Recommendation Report for Planning Permission for Works or Extension to a Dwelling

REF NO: BR/121/20/HH

LOCATION: 4 Sandymount Close
Bognor Regis
PO22 9EL

PROPOSAL: Single storey rear extension including demolition of existing conservatory.

North Elevation
Proposed

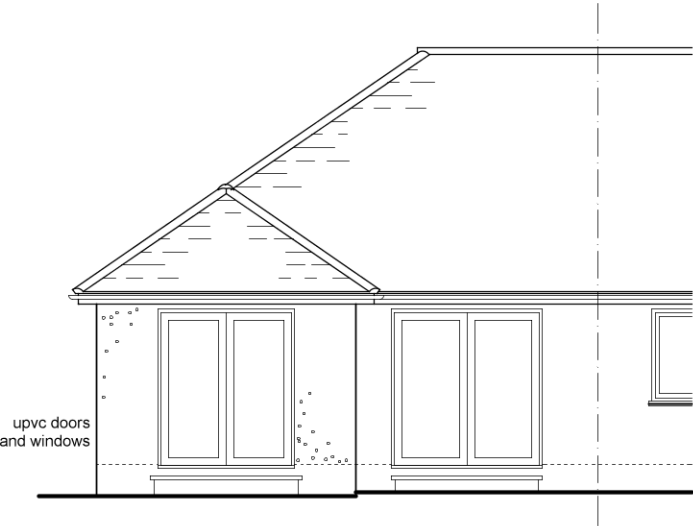
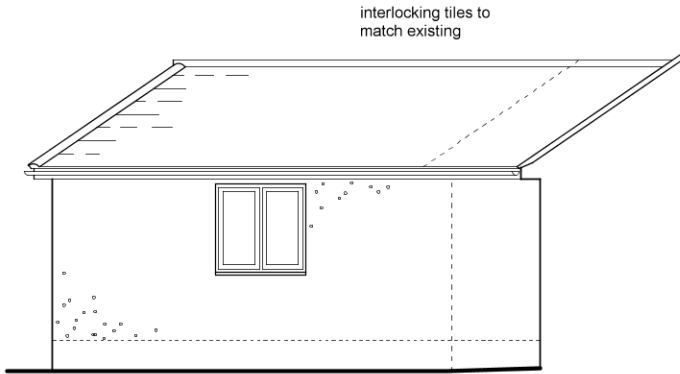
The addition appears subservient and will have a hipped roof which is considered to appear well integrated to the host dwelling.

The proposal will have a depth of 5.3m which is an increase of around 3.1m from the existing conservatory. The extension will although reduce slightly in width to 3.35m and will have a height of 4.05m and eaves to 2.85m.

There will be 2 windows to the both side elevations of the extension however at single storey, views are not considered to increase from that which are already achievable from the conservatory and garden.

Ground Floor Plan
Proposed

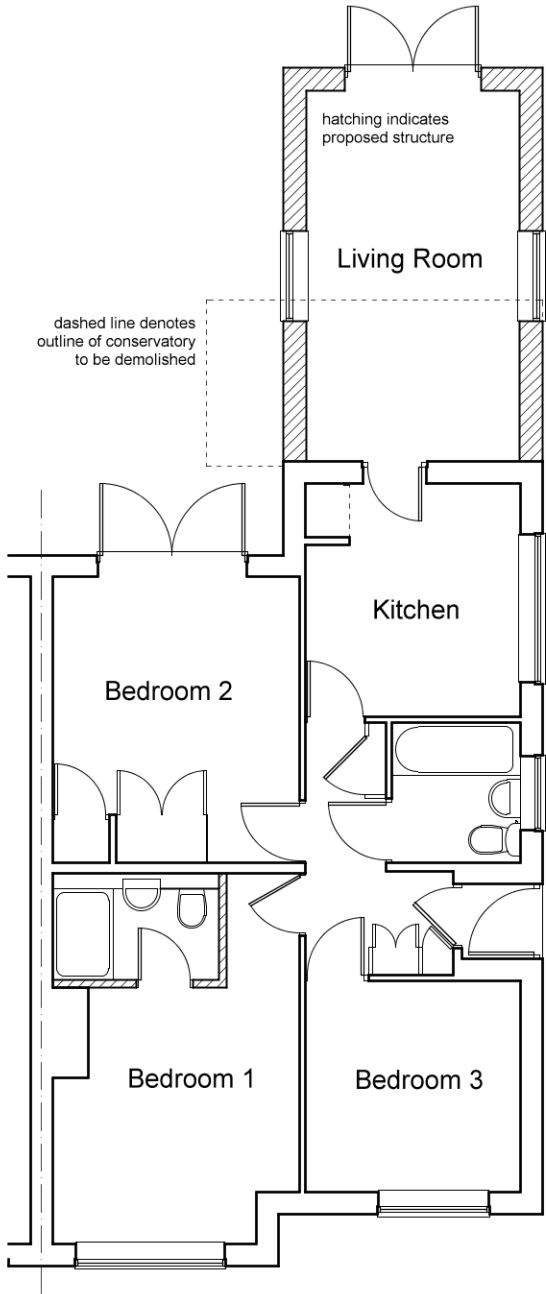
The addition retains a minimum of 3m to both side boundaries and 8.5m to the rear.
